CITY OF ALBUQUERQUE

February 13, 2015

**Re: Heritage Marketplace
Engineer's Stamp Date 1-29-15 (K09D026)**

SOUTHERLY Developed Basins

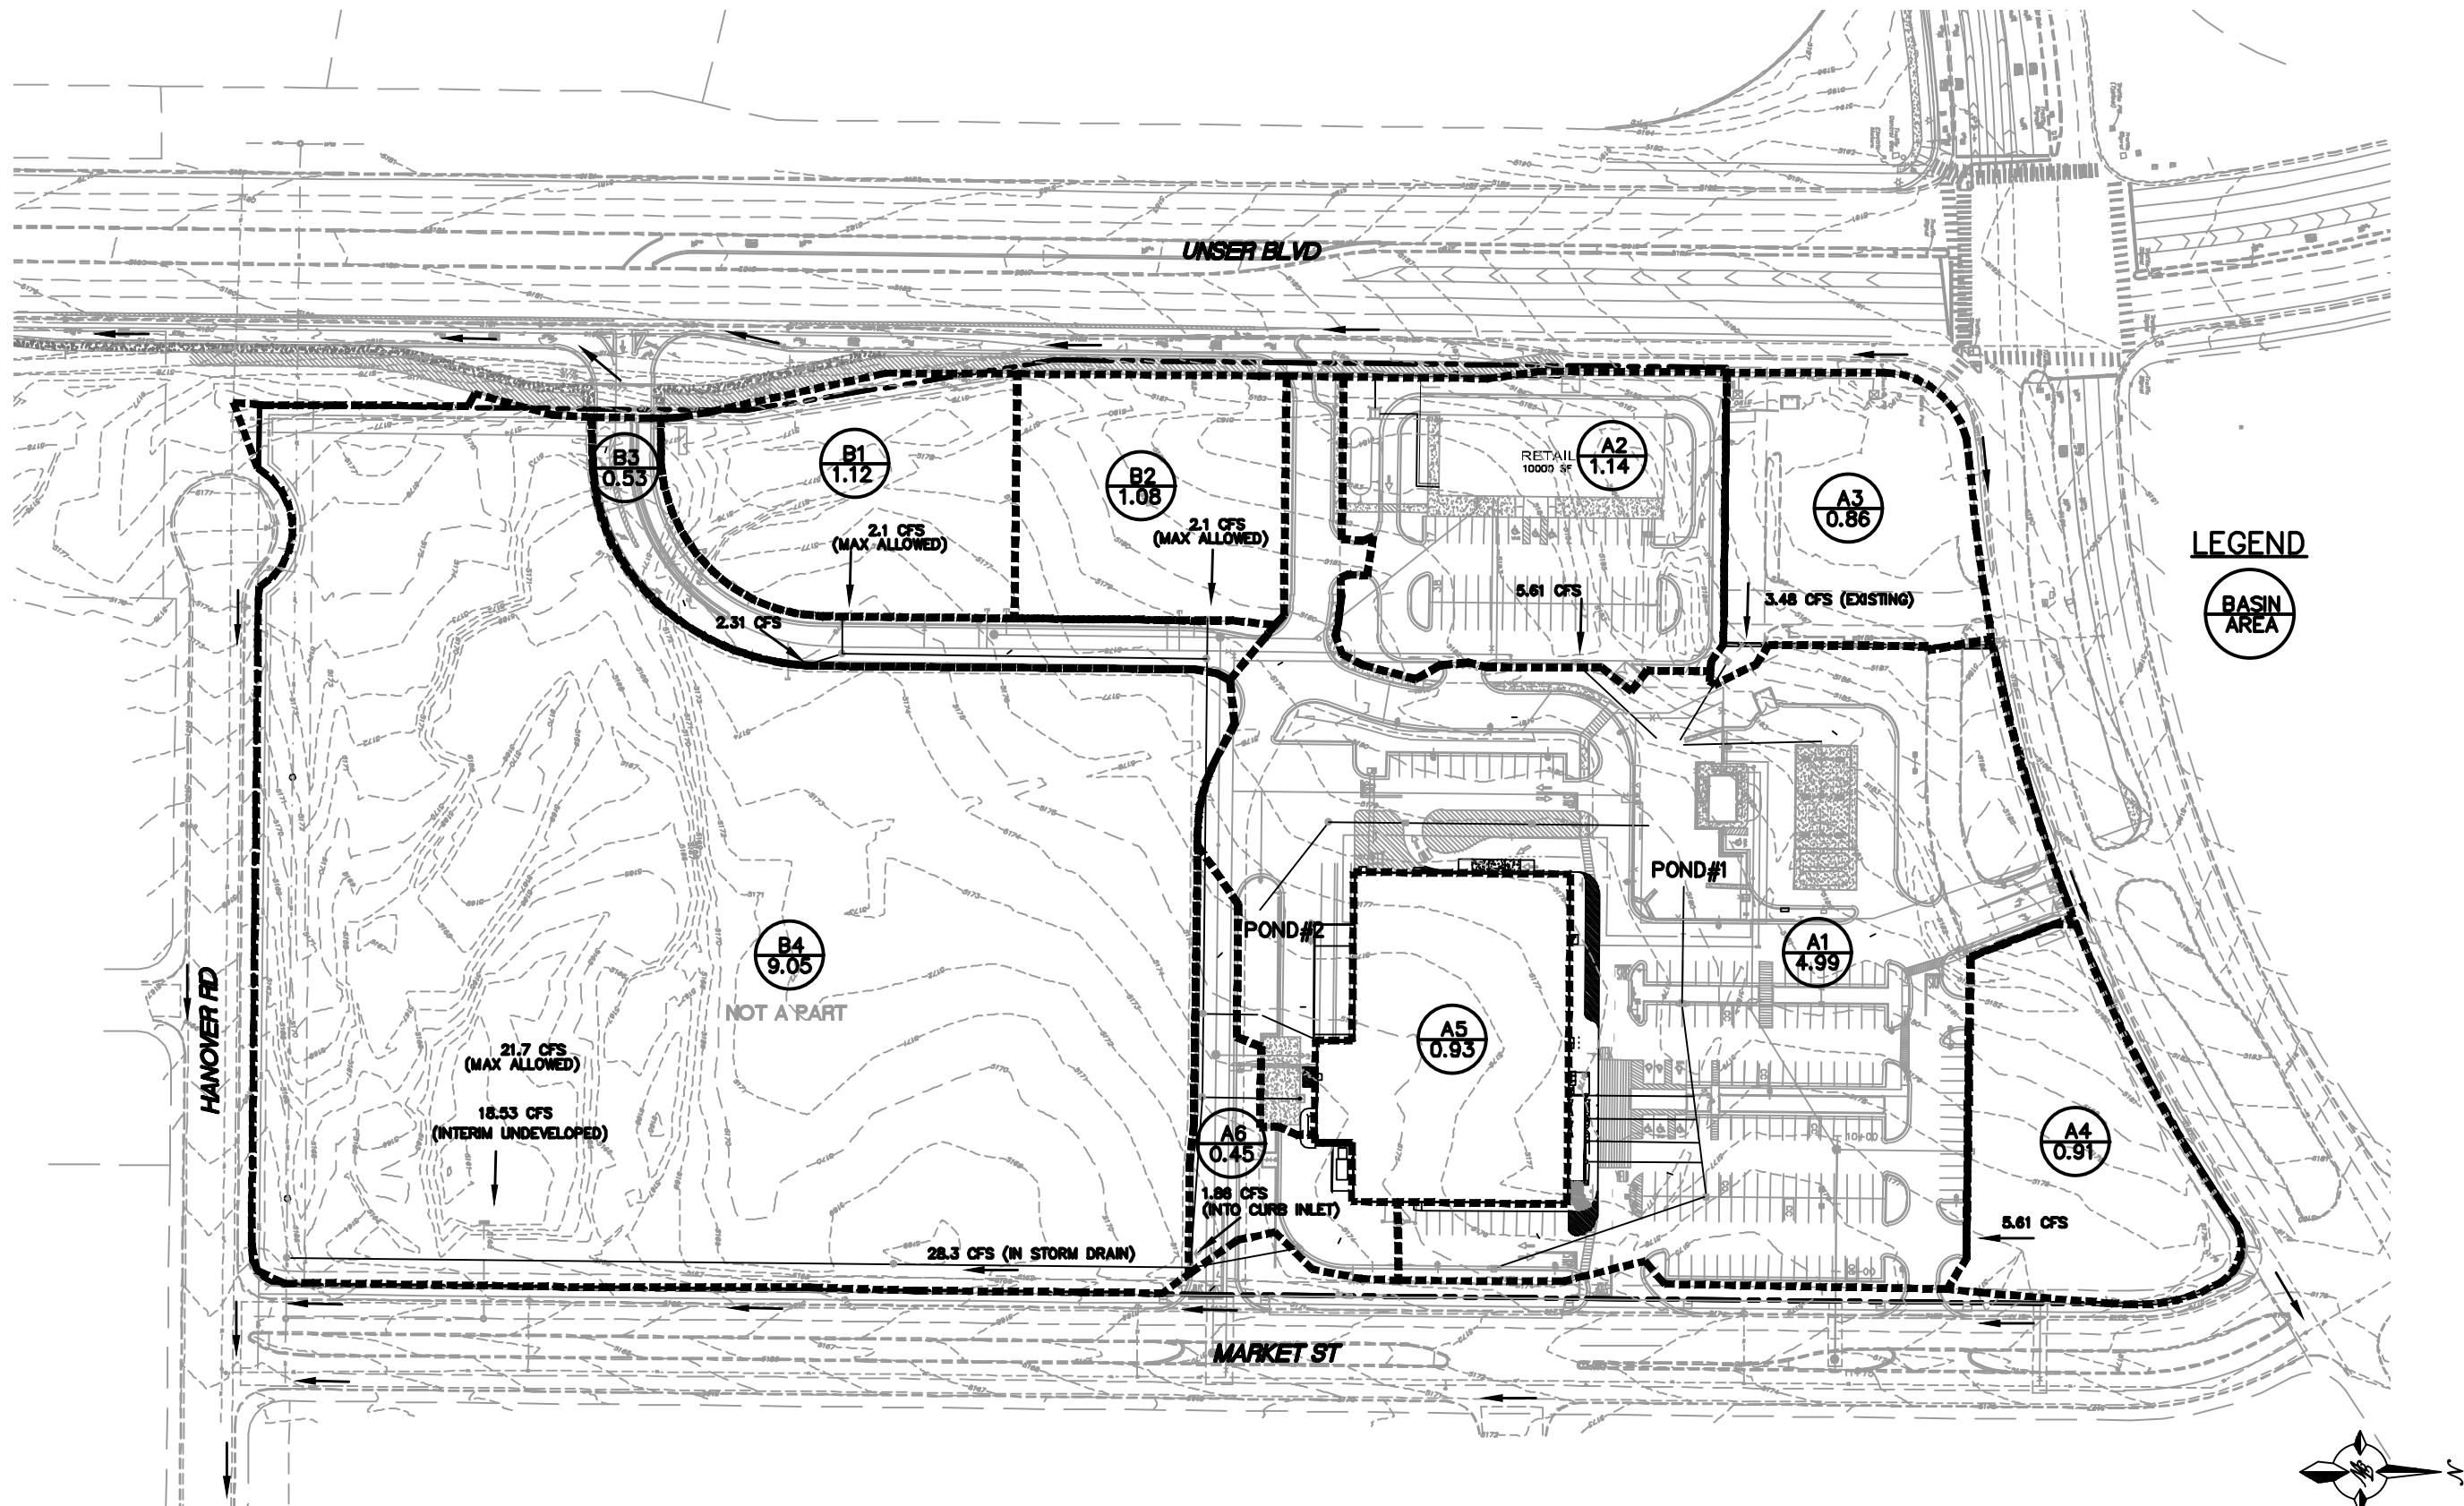
1. The flows shown on the SAD 212 Hanover Storm Sewer plans should be used as a basis for downstream capacity for this report rather than the Conceptual Drainage Drain for Tract 1, El Rancho Atrisco, Phase III, Isaacson and Arfman 1985.
 - a. Using the stationing on the SAD 212 as-built plans, it appears the allowable discharge for this area is 50 cfs minus the Market St ROW.
 - b. The allowable discharge per acre should be identified in the report.
